From: Mau, Russell E (DOH) <Russell.Mau@DOH.WA.GOV>
Sent: Monday, June 23, 2014 11:36 AM
To: Kaycee Hathaway
Cc: Sayers, Brian A (DOH); Holly Duncan
Subject: RE: Notice of Application : CU-14-00002 NMF Enterprises

Subject: Notice of Application : CU-14-00002 NMF Enterprises

Hanson Short Plot Amendment
13-00008, Lot 1A, SEC 18, TWP
19, RGE 16

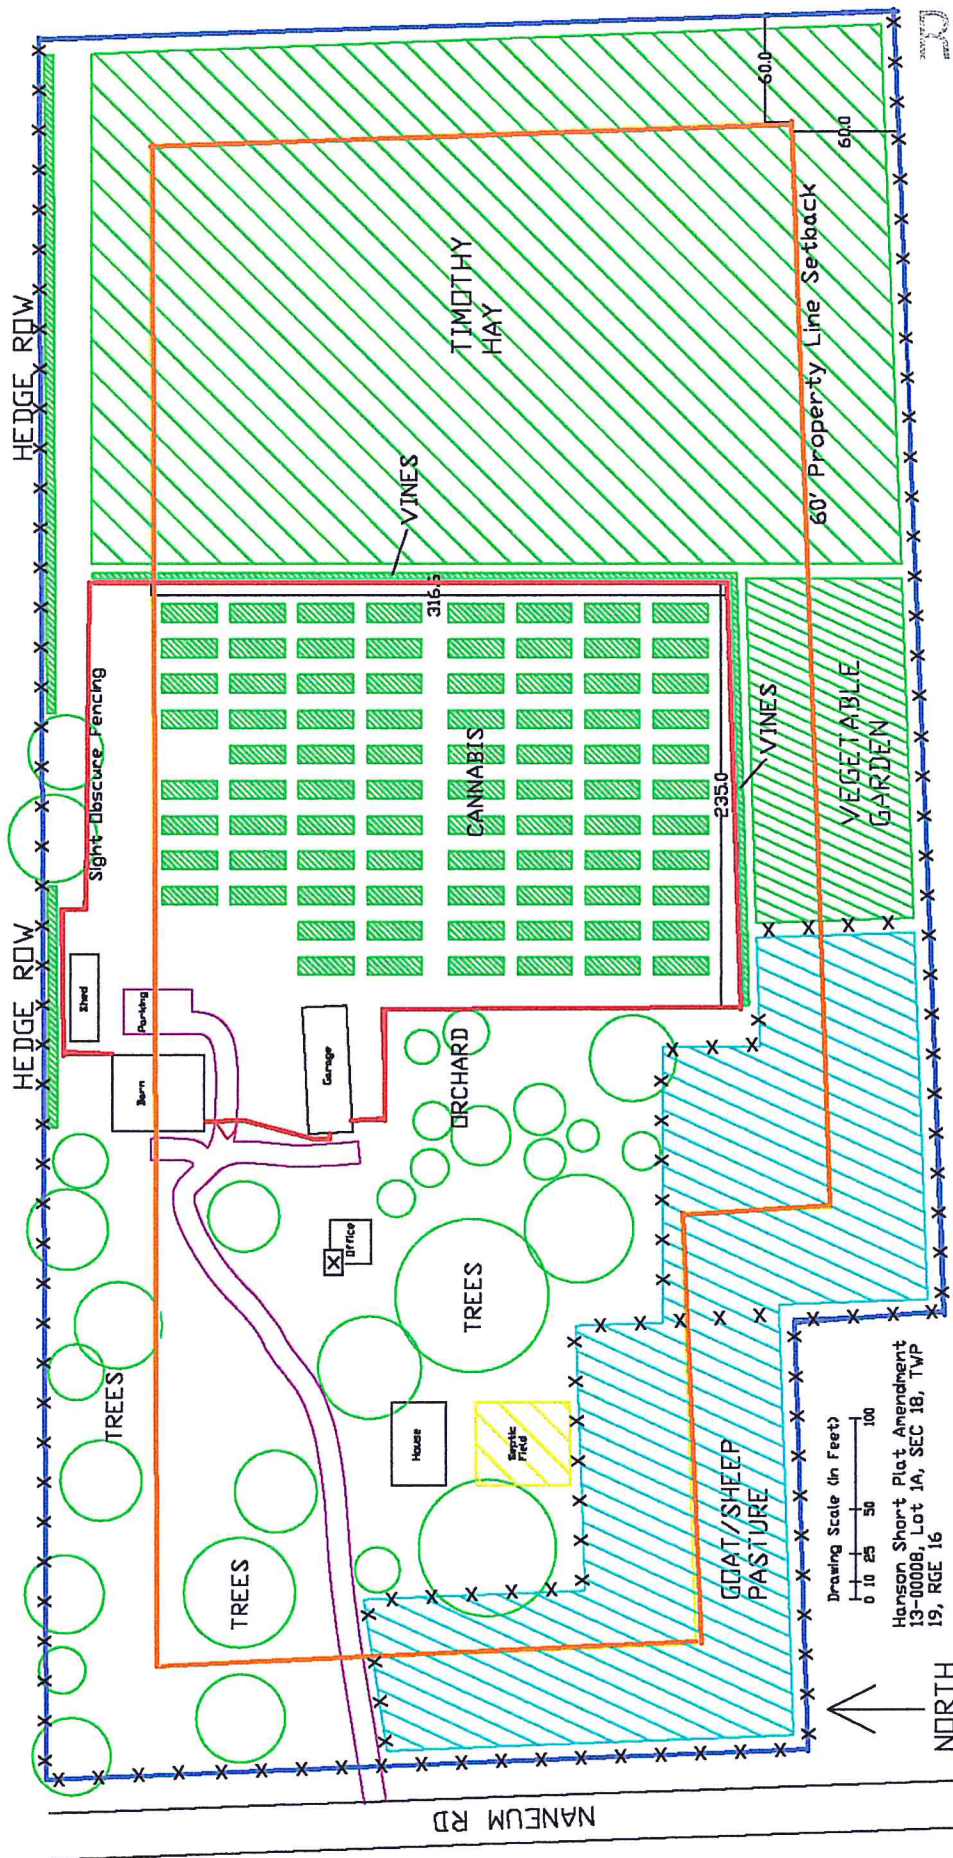
The submittal indicates water is on-site – what is the number of employees and number of water system connections for this business?

This may be a Group B or Group A water system, depending on the answer(s) to my questions.
